Application for a Non-Material Amendment Following a Grant of Planning Permission

Number	1
Suffix	
Property Name	
Address Line 1	Hudson Drive
Address Line 2	
Address Line 3	West Sussex
Town/city	Rustington
Postcode	BN16 2AX

Single storey side extension, new front porch canopy, front gable roof alteration, installation of rear dormer, and rooflights.

R/73/25/HH

PROPOSED AMENDED
ELEVATIONS BEING
SUBMITTED UNDER THIS
APPLICATION

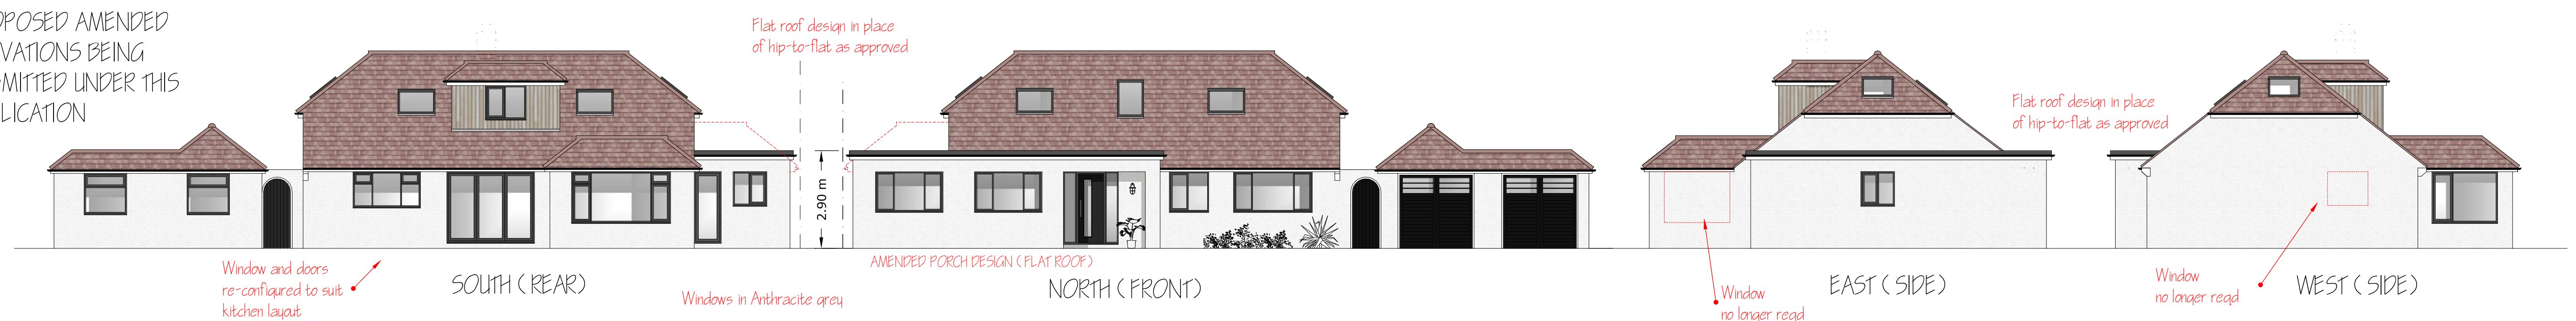
WINDOW COLOUR CHANGE - ANTHRACITE GREY
PORCH DESIGN CHANGE INCLUDING FLAT ROOF TO FRONT AND SIDE EXTENSIONS
NEW WINDOW TO EAST ELEVATION REMOVED
NEW WINDOW TO WEST ELEVATION REMOVED
RE-CONFIGURATION OF KITCHEN DOORS/WINDOW
